Engineers Comments Regarding Surface Water Drainage

Application Reference:	WA/28/26/DOC	Reviewer Reference:	ADC/EXT5/AF
Planning Officer:	Amber Willard	Date of Review:	22/06/2026
Site Name:	Stoneybrook Farm Eastergate Lane Walberton BN18 0BA		
Application Description:	Approval of details reserved by condition under WA/108/24/PL relating to condition 3- Surface Water Drainage.		
Assessment Number:	2

Application Reference: WA/28/26/DOC Site Name: Stoneybrook Farm Eastergate Lane Walberton BN18 0BA	Initial Issue Date: 30/04/2026 Issue Date: 22/06/2026 Reviewer Reference: ADC/EXT5/AF
---	---

Basin Embankment Detail
Scale 1:50

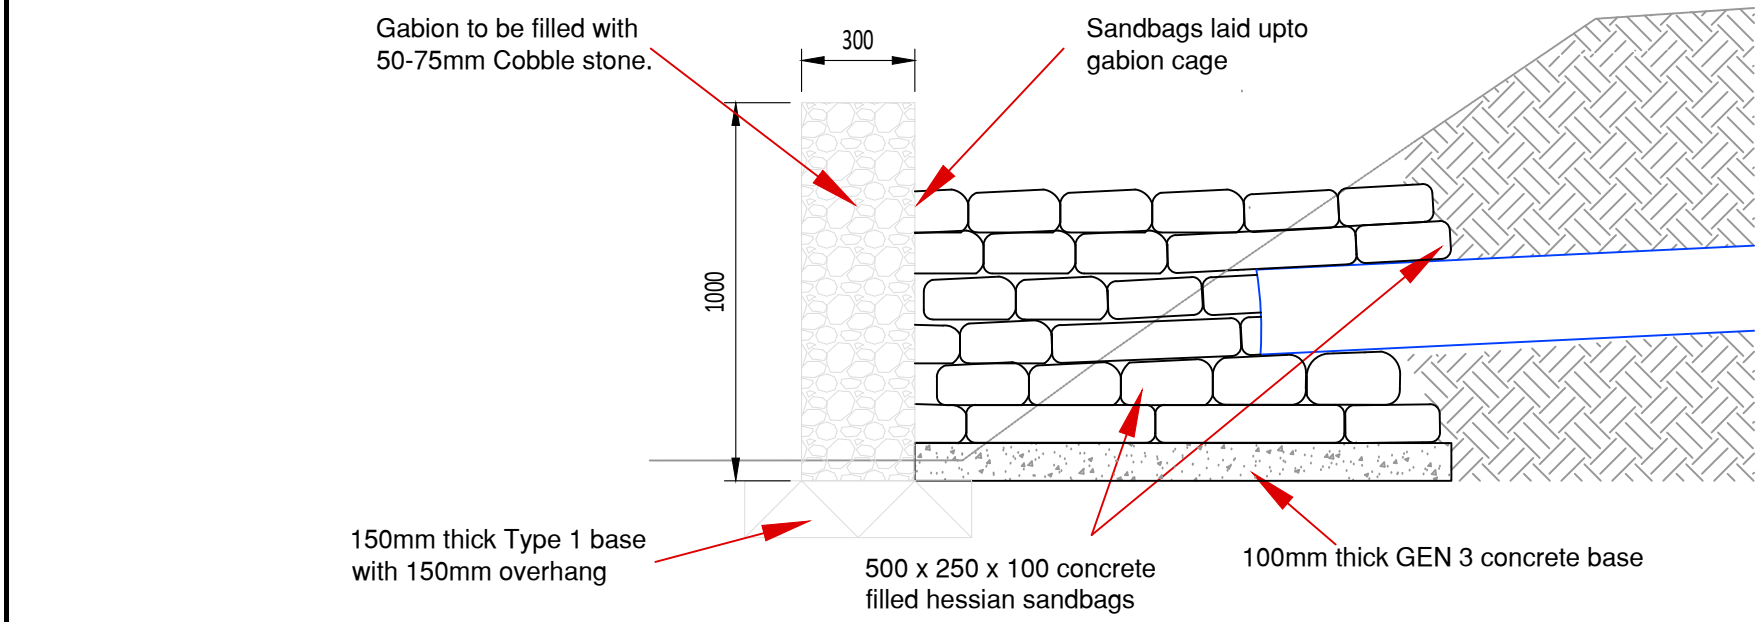
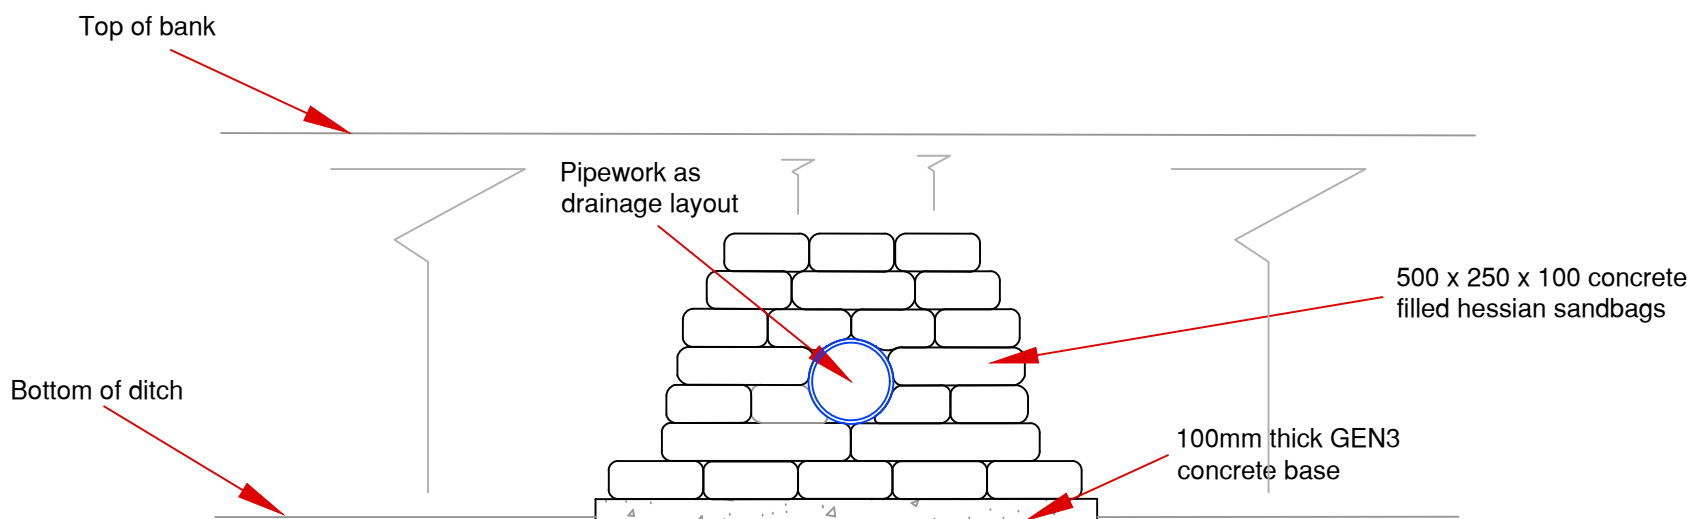
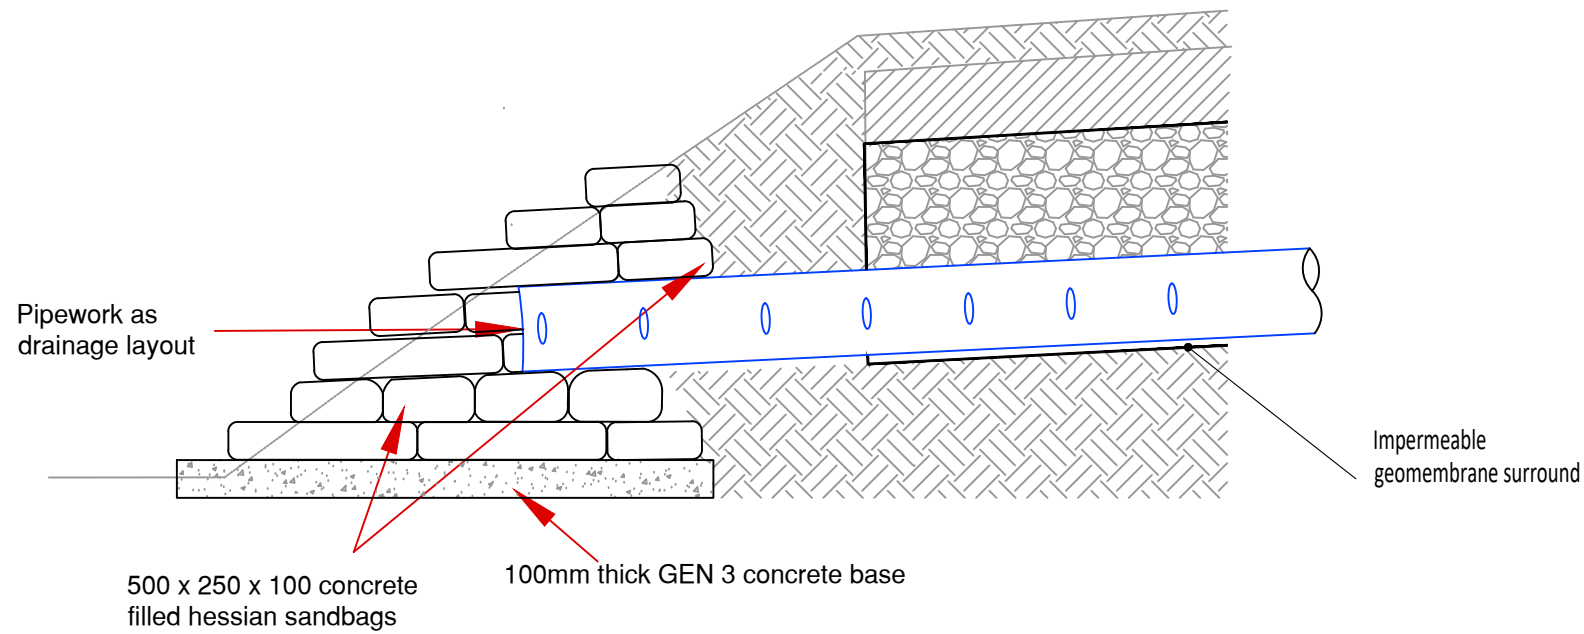
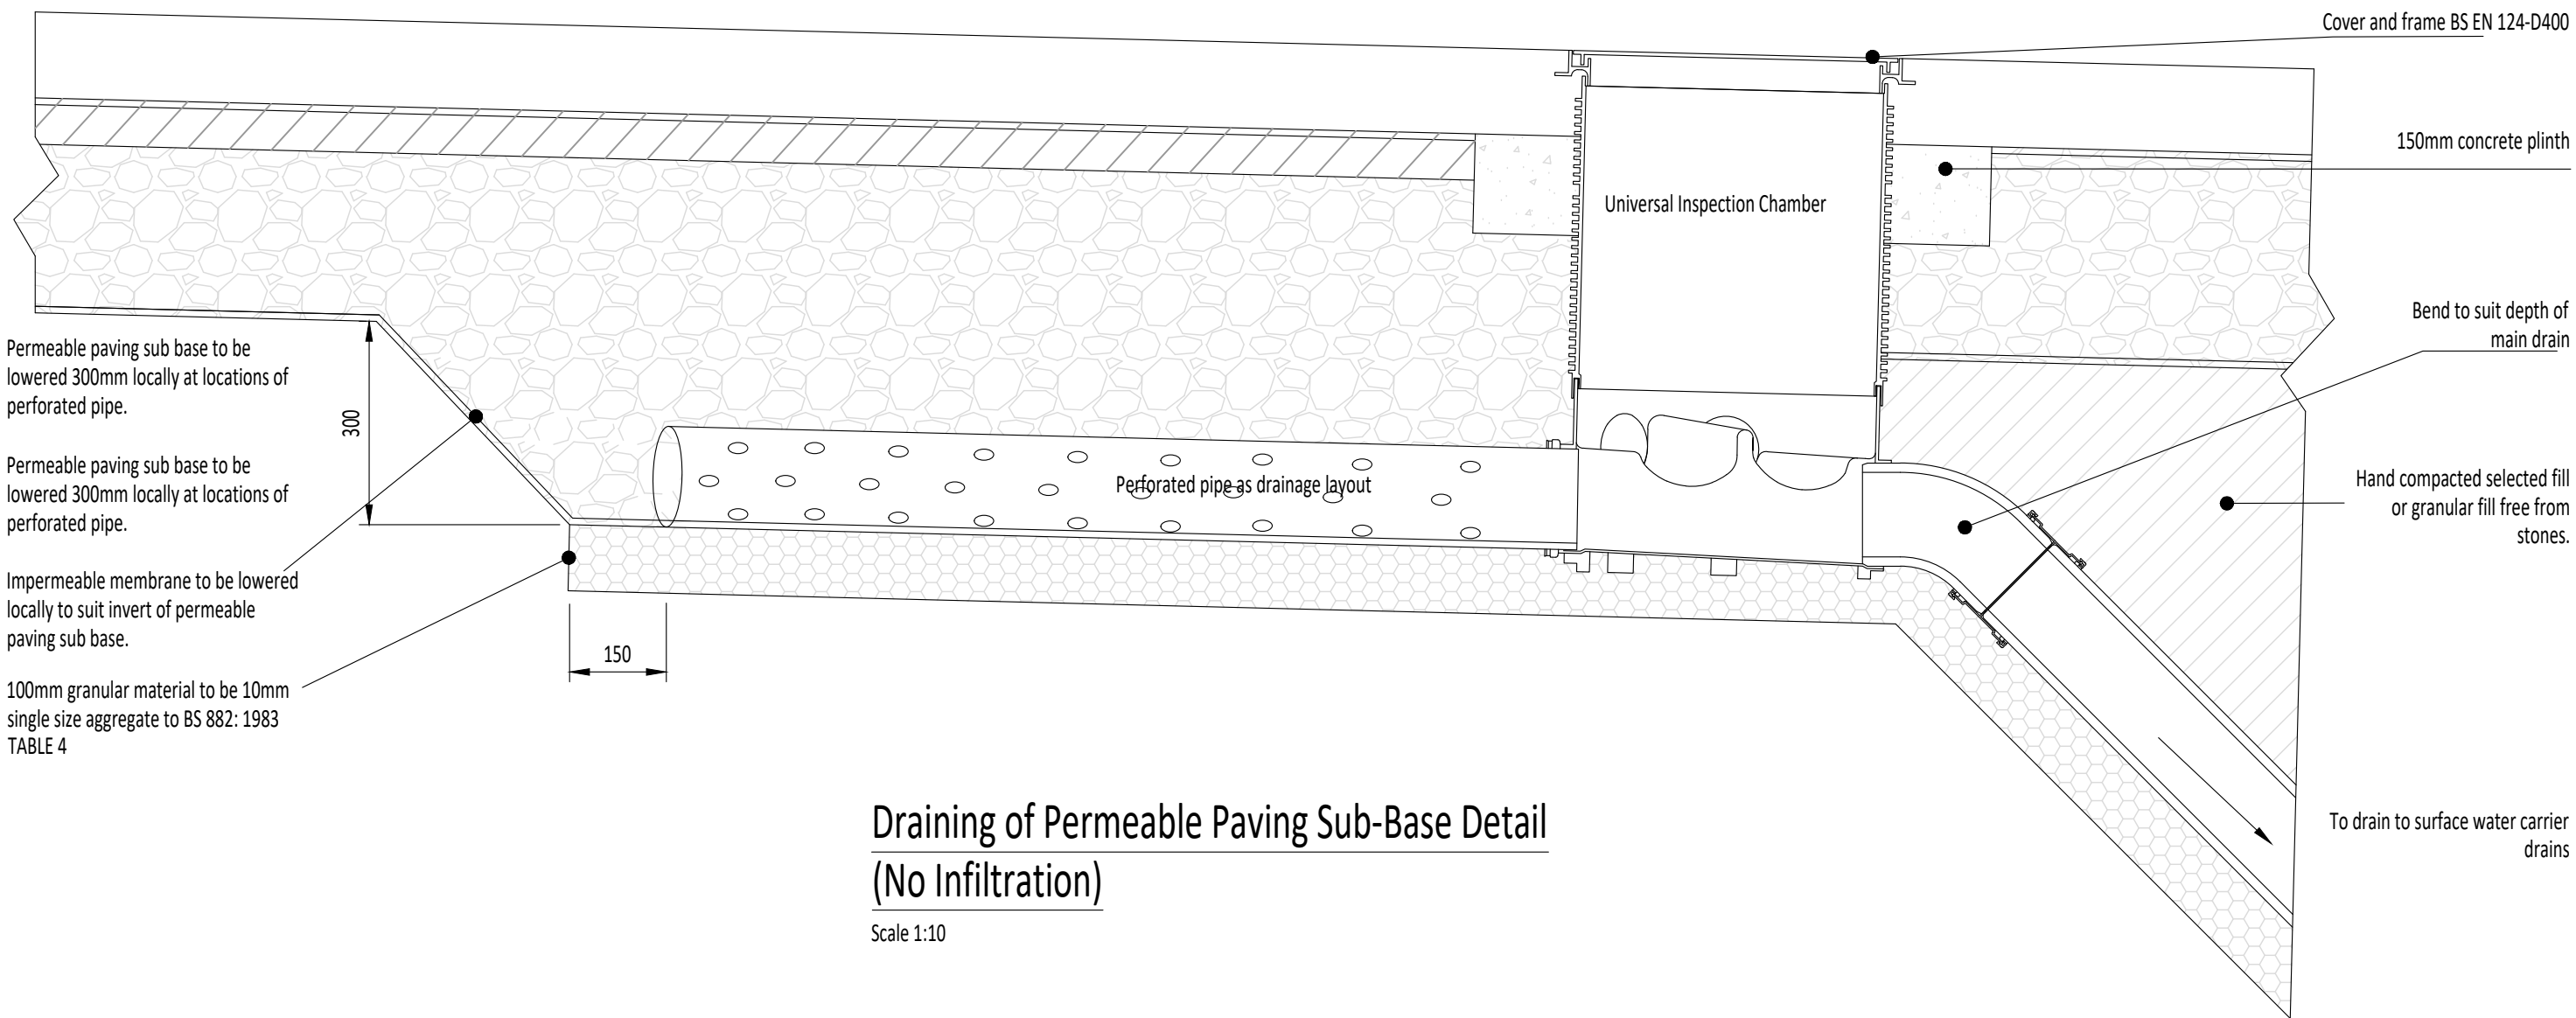
3.	The use of the pond for interception drainage is not suitable as the top water level would be at the overflow level during winter.	The groundwater level is recorded at 10.333m, the outfall level is 10.383m allowing for 50mm of be retained in the pond and allowed to infiltrate through the sides. The interception volume will be 12.5m ³ .	The attenuation feature would need to act as a basin it be acceptable for interception drainage. Calculations should be provide for the area served.

4.	The full ground investigation report should be provided.	Groundwater site investigation has been carried out to determine the viability for infiltration as the primary discharge of surface water. The investigation found groundwater to be within 1m of the existing ground level and therefore compliance with the design standards could not be achieved, making infiltration not viable. BGS mapping shows Head Deposits-Gravel, Sand, Silt and Clay over a bedrock of London Clay. Plans attached. The immediate neighbouring site during their site investigation correlated with the BGS and groundwater monitoring confirming groundwater within 1m of existing ground level.	Since the system has been categorised as not suitable for infiltration, the basin should be lined as it extended 2m into existing ground levels. There will need to be sufficient ballast above the liner to resist floatation forces.

5.	Anti-floatation calculations should be provided for the basin.	The base of the basin will remain as dug material to allow the ground water to rise into the pond during the winter time and allow some infiltration during periods where no groundwater is present	This is not acceptable as groundwater may reduce available volume for infiltration.

6.	Construction details should be provided for the basin construction and liner.	Details have been provided.	The detail will need to be revised, see comments above.
